Y/97/21/DOC

Bonhams Field Main Road Yapton BN18 0DX

Approval of details reserved by condition imposed under Y/63/19/RES relating to condition 5-details of construction & materials of all front openings, windows & doors for plots 2-7, 19-21, 36-41 & front & right hand side openings, windows & doors for plot 1

Typical detail
Window head sill and jamb
in brick elevation

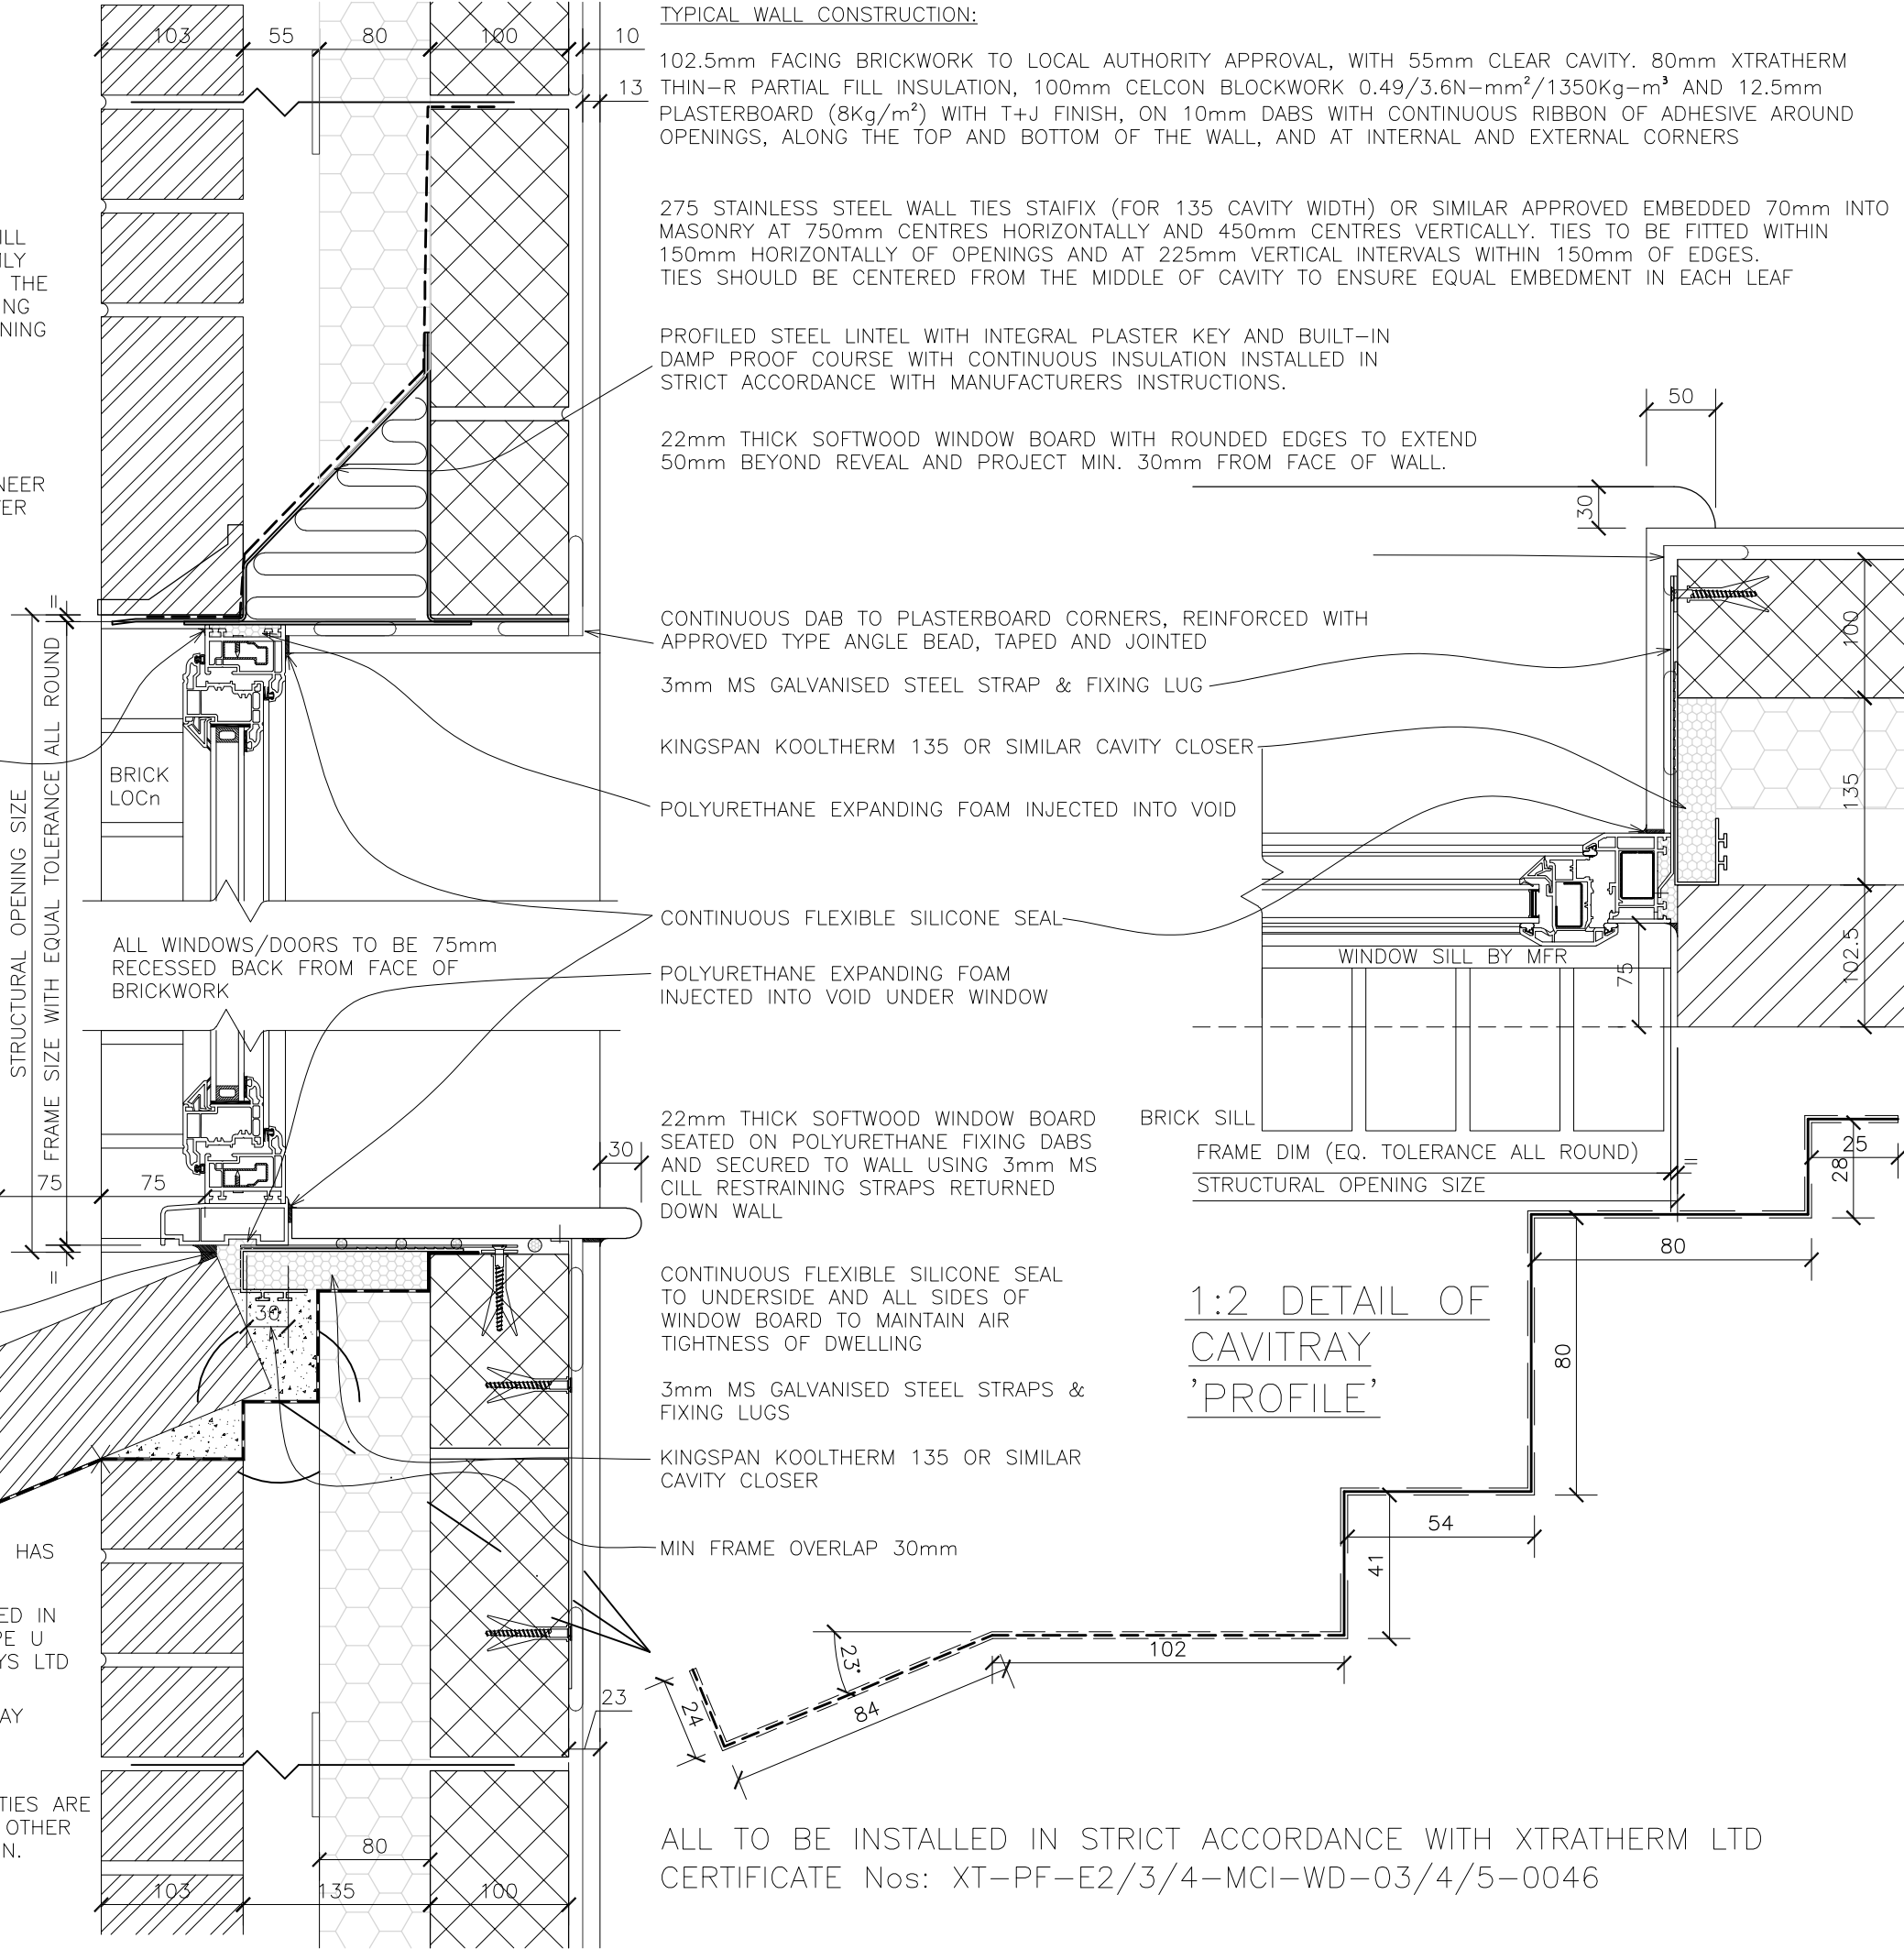
Plots 1, 2-7, 19-21, 36-41 are those closest to the heritage assets (listed buildings and conservation area). As a result, it was assumed that the intention was that those buildings should be constructed using traditional materials. The reason for this being to attempt to reduce the impact of the new development upon them. At present, this does not appear to be the case with the proposed materials etc. For instance the use of UPVC windows is disappointing, and cannot be supported.

Client		Seaward	
Job title		Bonhams Field	
Drawing title		Yapton	
General Arrangement		Elevations	
Plots 36, 37		Scale at A1	
Drawn	Date	Checked	Date
GW	13.01.21	PWV	15.01.21
Job No.	Pro.	Org.	Zone
20-202	BHF	MHA	00
Purpose of Issue	Level	Type	Role
	ZZ	DR	A
			No.
			Rev.
			0132
			P01

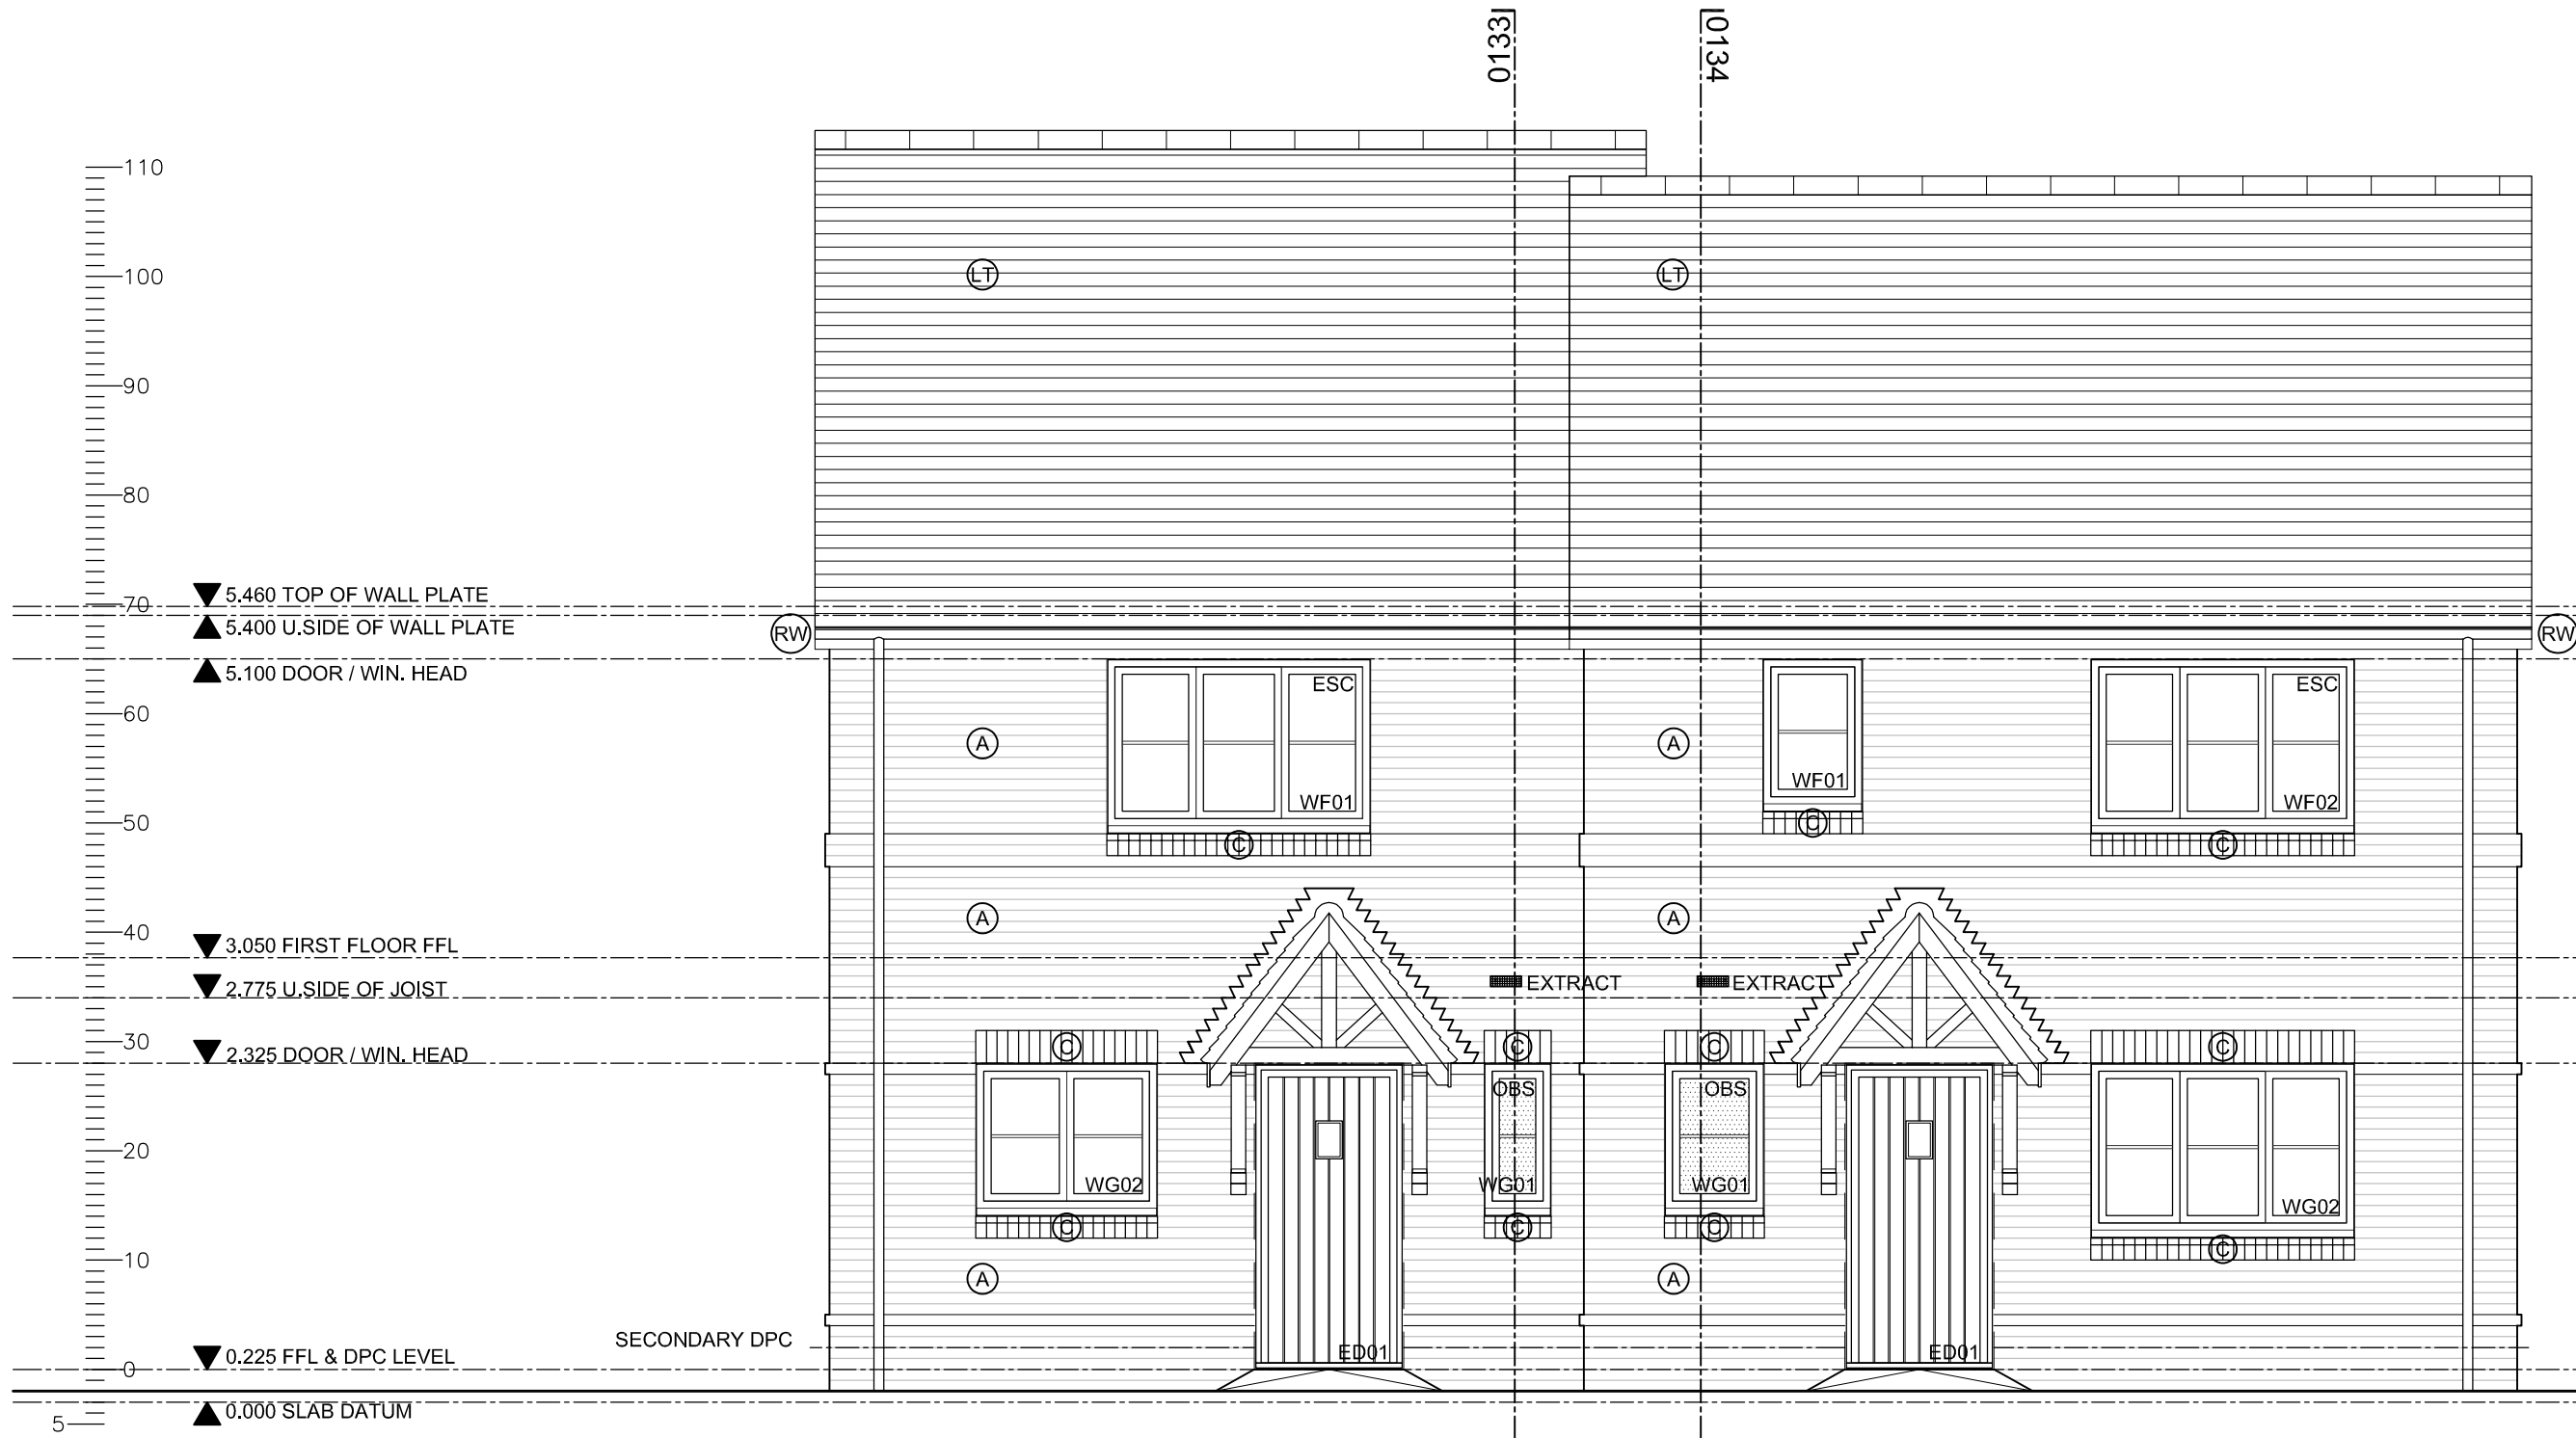
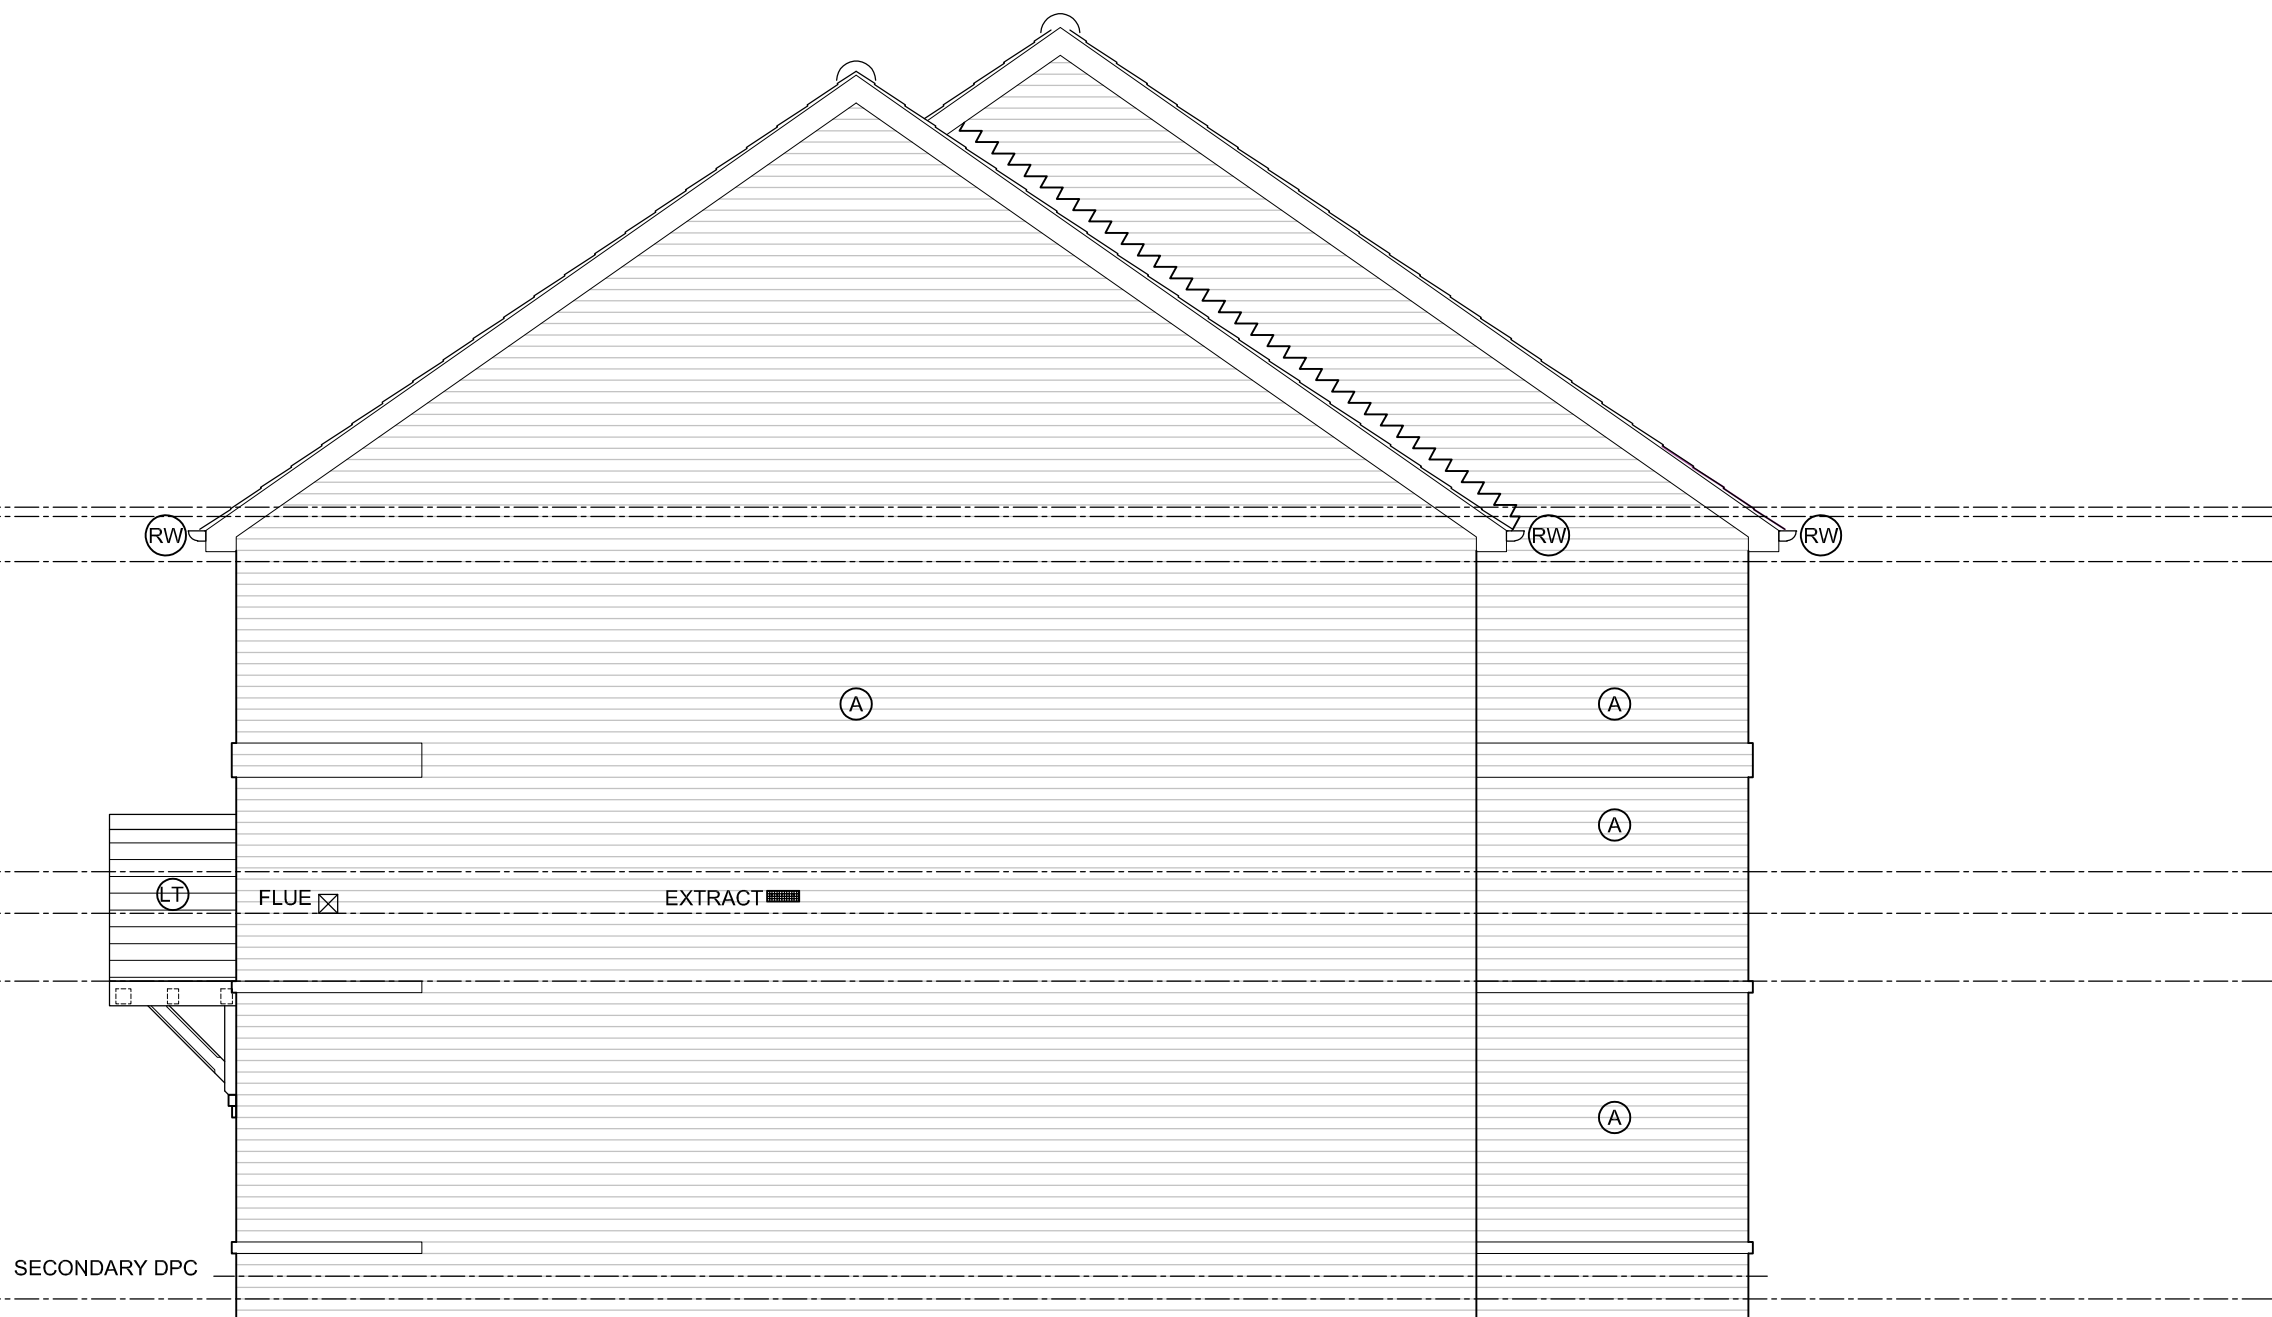
First of all it would have helped to have the general arrangement elevations of all of the units identified within the original condition as opposed to just six of them.
